EL PASO COUNTY STORMWATER MANAGEMENT PLAN CHECKLIST

EPC Project Number: PPR2318

DRAWN BY:	DESIGNED BY:
JS	JS/RG
JOB NUMBER:	1070.0026
DATE:	9/12/23
SCALE:	1" = 20'
DRAWING DESCRIPTION:	GEC PLAN
SHEET NO.:	3 of 5

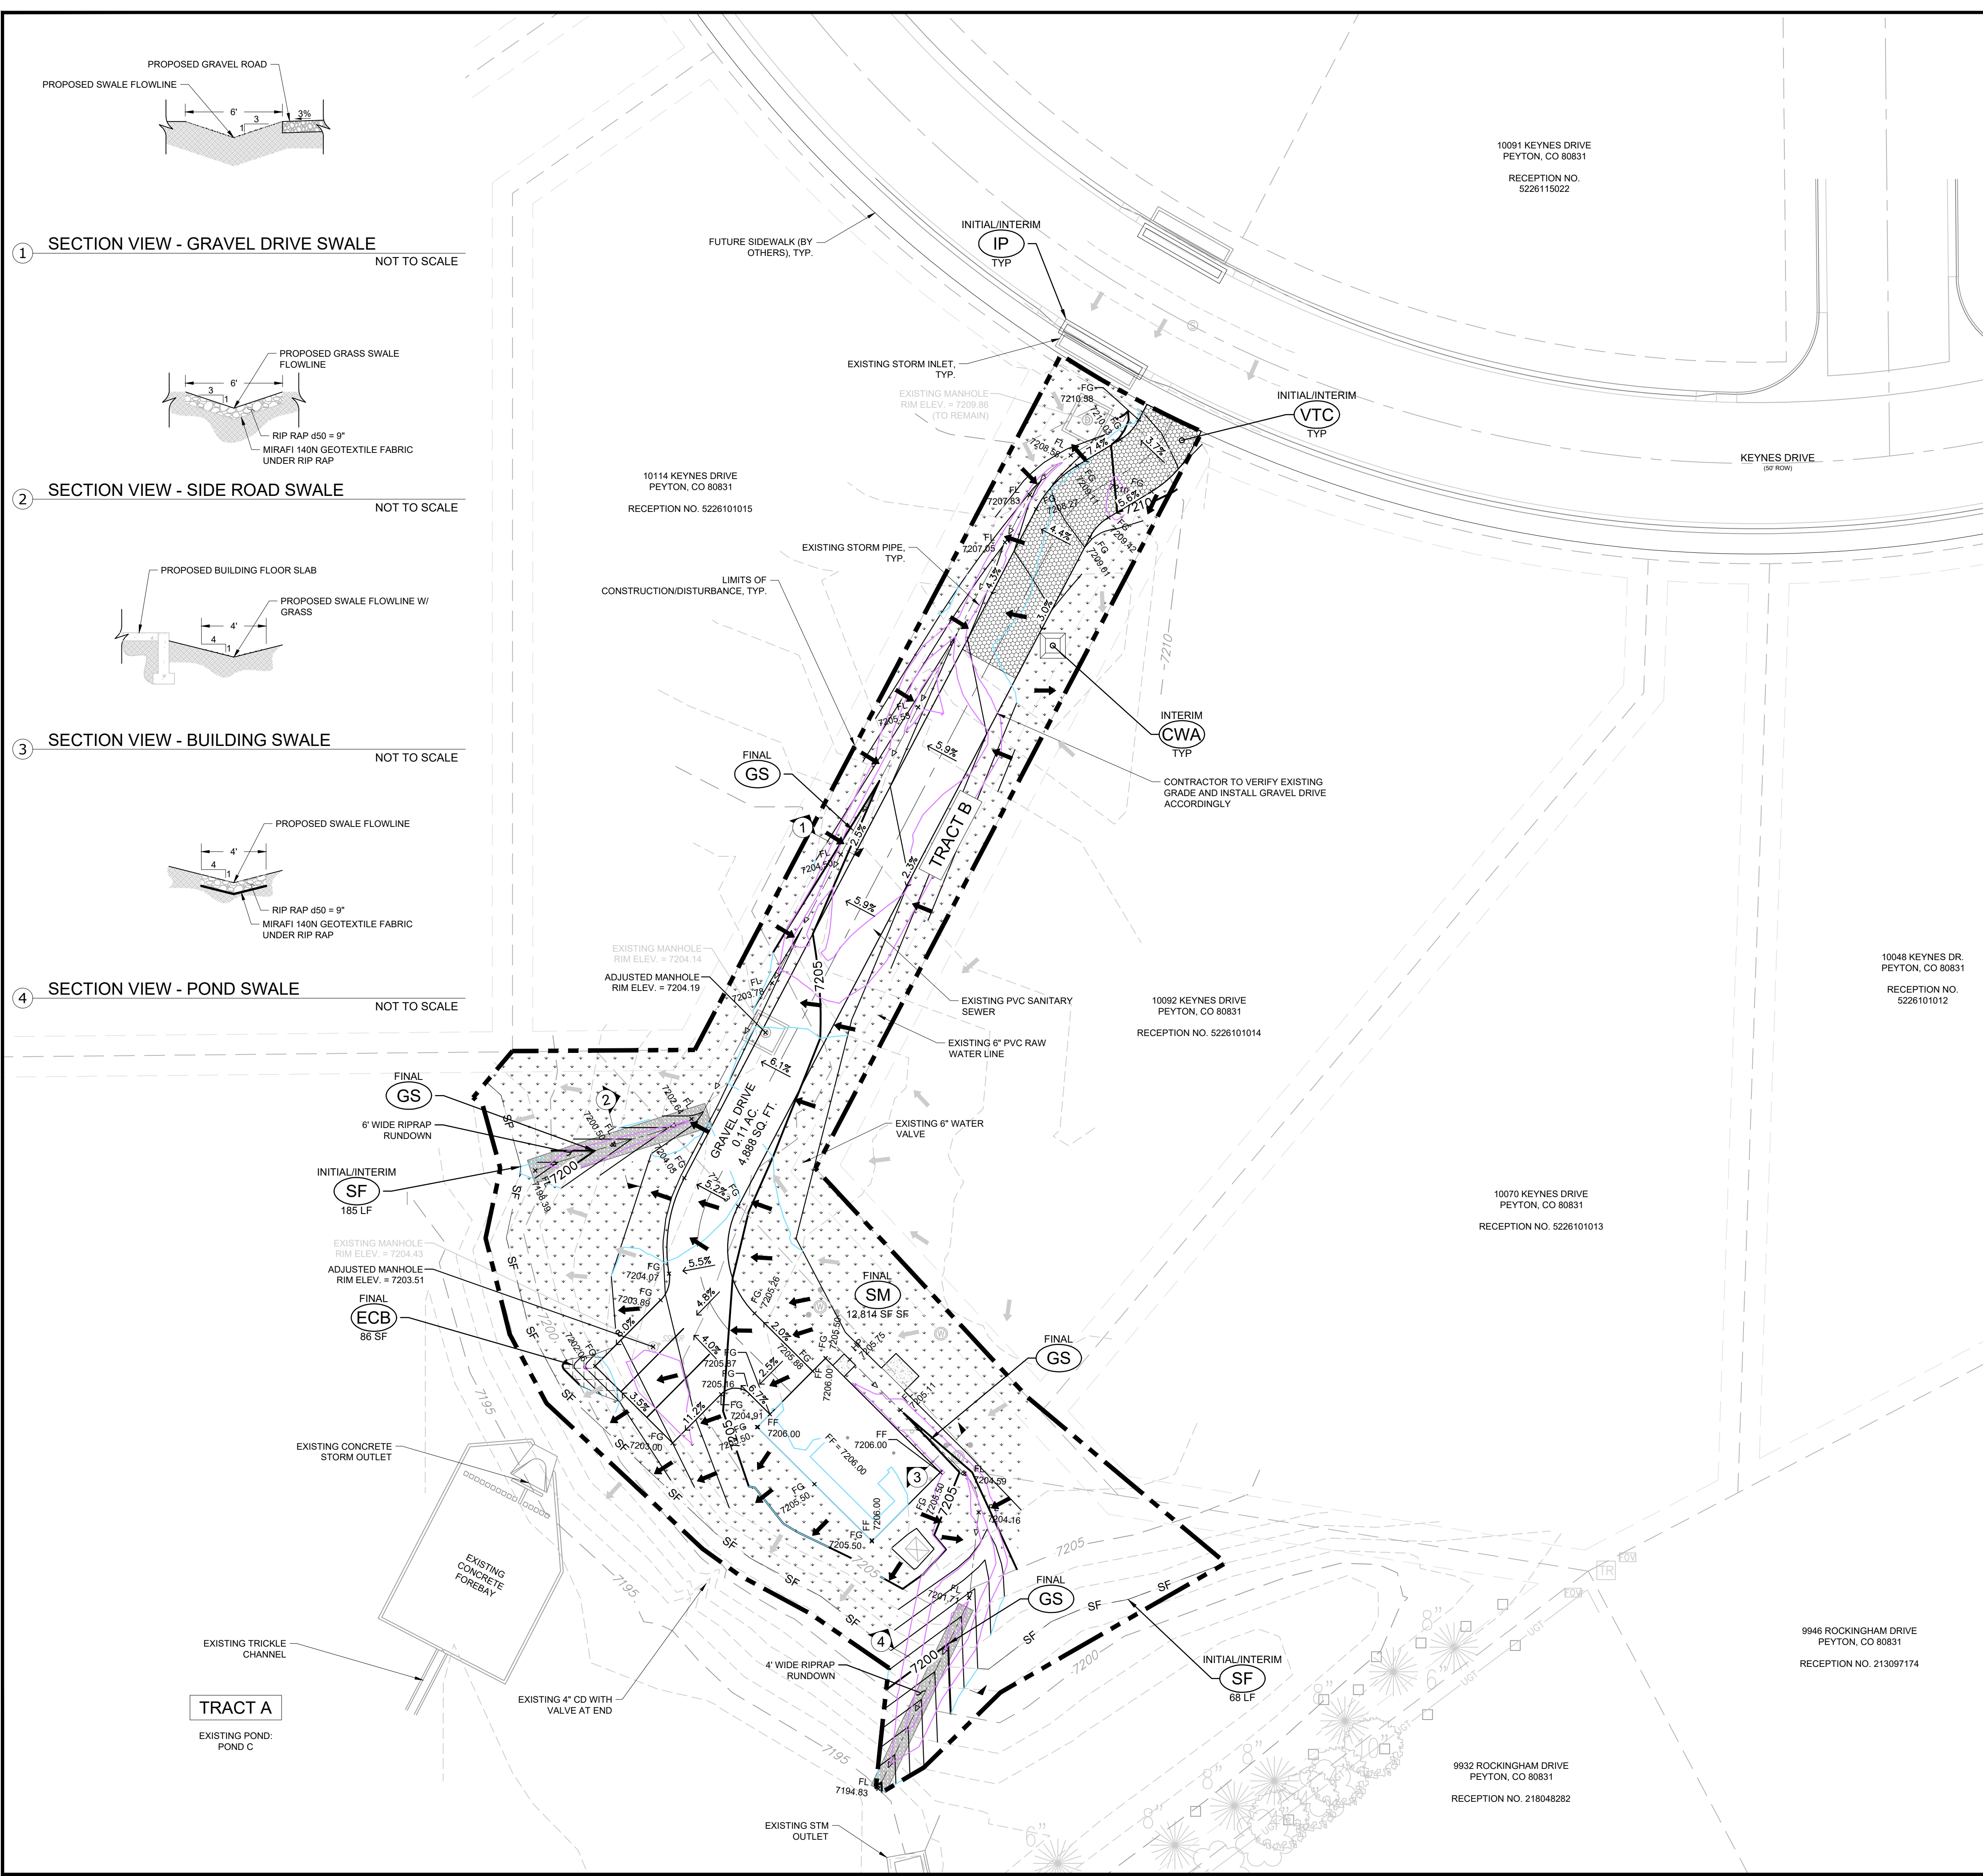
Applicant	EPC
17	SWMP Map to include: Reviewed GEC Plan		
17a	construction site boundaries		Y
17b	flow arrows to depict stormwater flow directions		Y
17c	all areas of disturbance		N
17d	areas of cut and fill		N
17e	areas used for storage of building materials, soils (stockpiles) or wastes		Y
17f	location of any dedicated asphalt / concrete batch plants		N
17g	location of all structural control measures		Y
17h	location of all non-structural control measures		Y
17i	springs, streams, wetlands and other surface waters, including areas that require maintenance of pre-existing vegetation within 50 feet of a receiving water		Y
18	Narrative description of all structural control measures to be used. Modifications to EPC standard control measures must meet or exceed County-approved details		Y
19	Description of all non-structural control measures to be used including seeding, mulching, protection of existing vegetation, site watering, sod placement, etc.		Y
